KITTITAS COUNTY

DEPARTMENT OF PUBLIC WORKS

MEMORANDUM

TO: All Staff
FROM: Public Works Planning Review Team
DATE: May 17, 2021
SUBJECT: VA-21-00004 Hatcher

HATCHER

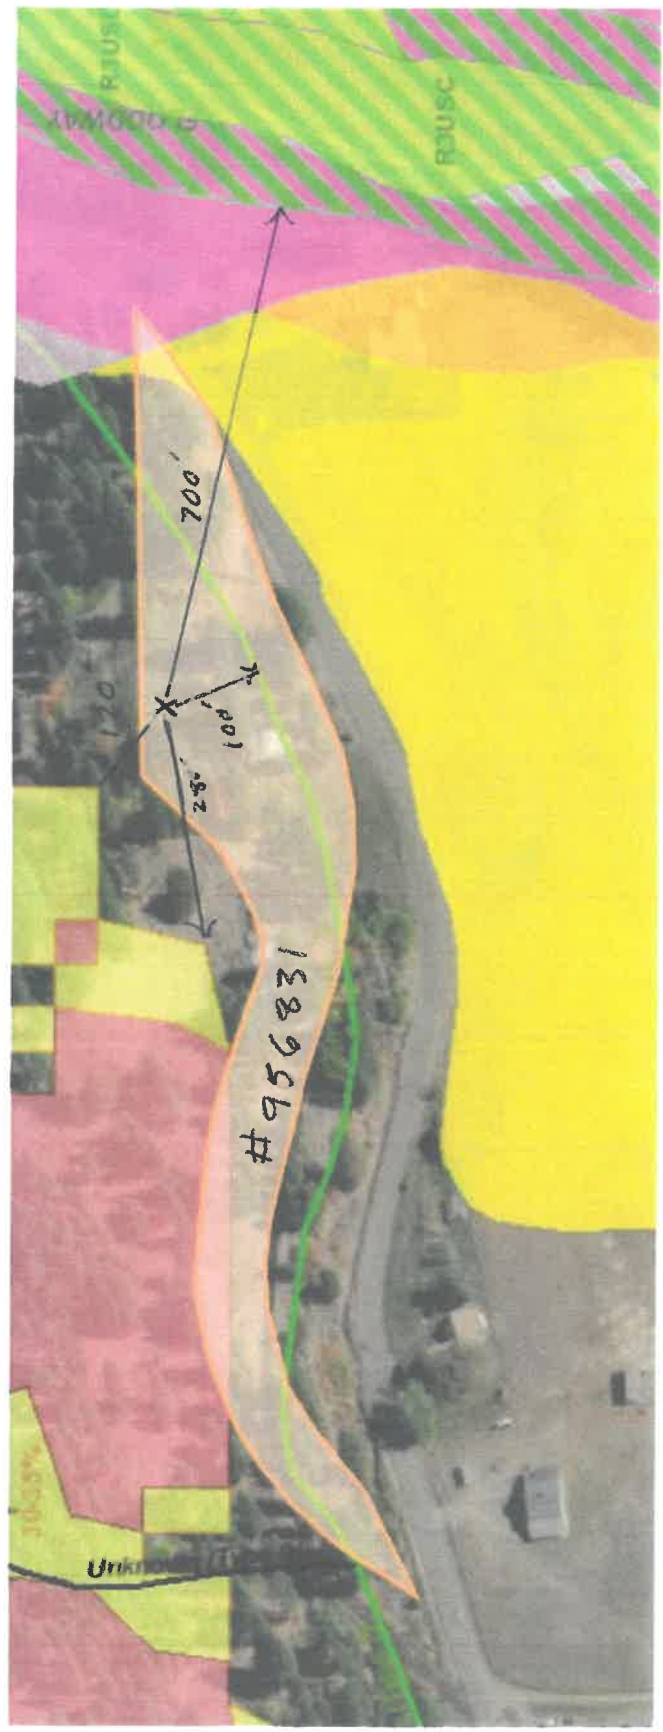
1. A structure cannot be constructed within an easement or right-of-way. The proposed location of the structure is located within the 10-foot public utility easement dedicated by The Duke Short Plat.

SITE PLAN
LYNN HATCHER
5951 RED BRIDGE RD
PARCEL # 956831

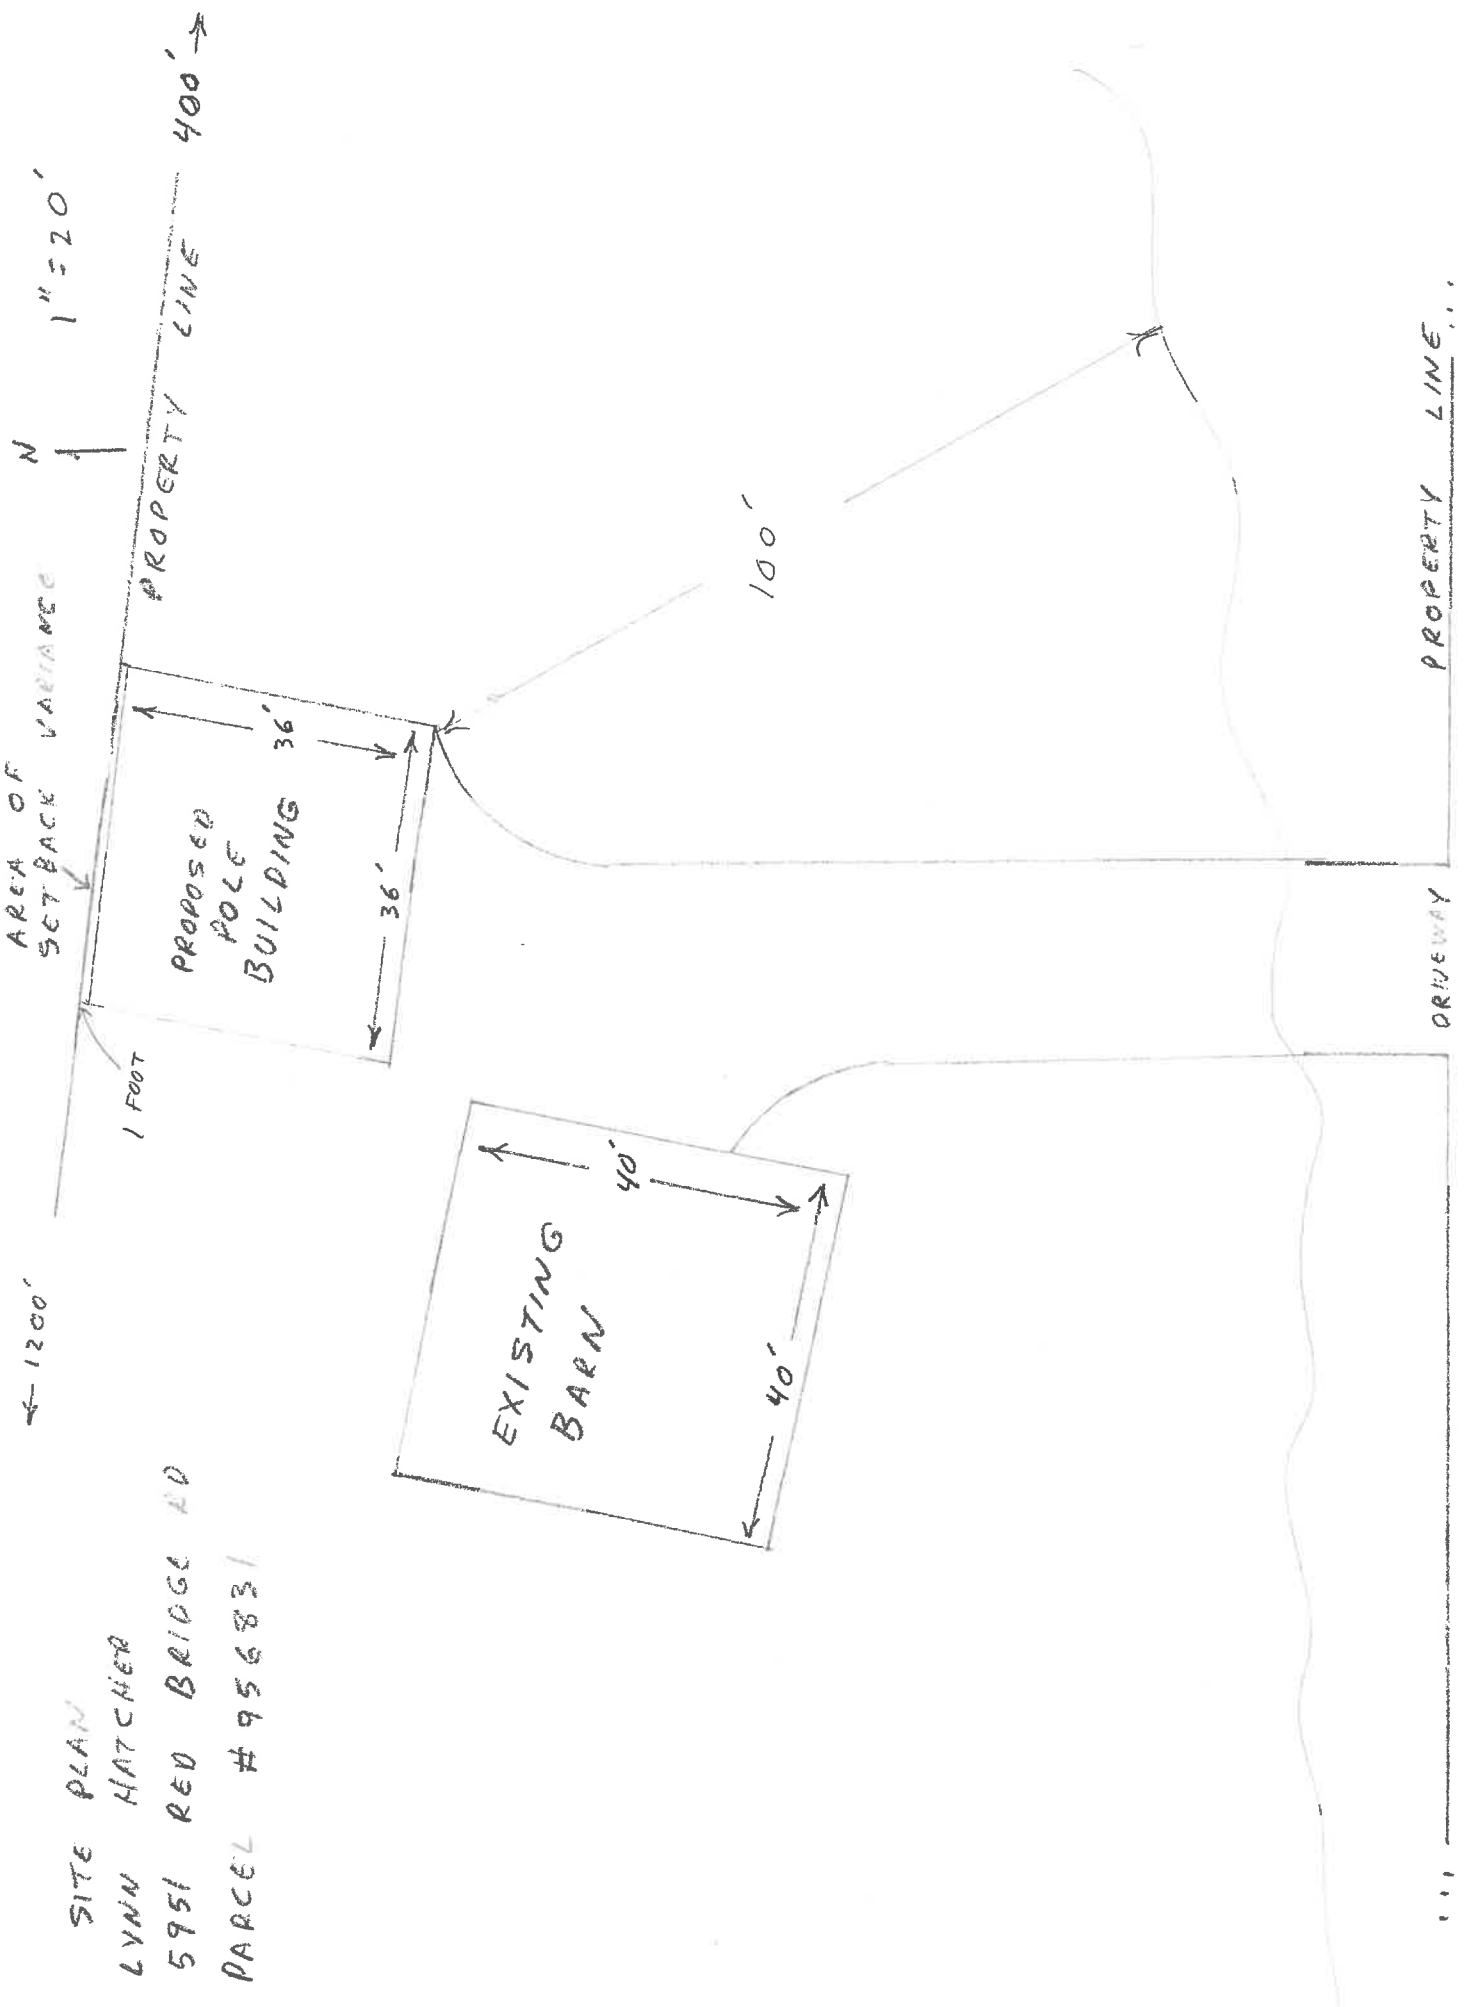
The Duke Short Plat Note 3: A public utility easement 10 feet in width is reserved along all lot lines. The 10-foot easement shall abut the exterior plat boundary and shall be divided 5 feet on each side of the interior lot lines.

1. A one-foot setback poses constructability problems without trespassing into the neighboring parcel. I believe a written statement from the neighboring landowner approving a short-term construction easement would suffice.
2. Building footings, grading, overhangs and swinging doors cannot trespass into the neighboring parcel.
3. Given the tight tolerances required, having the boundary line staked by a land surveyor prior to construction should be required.
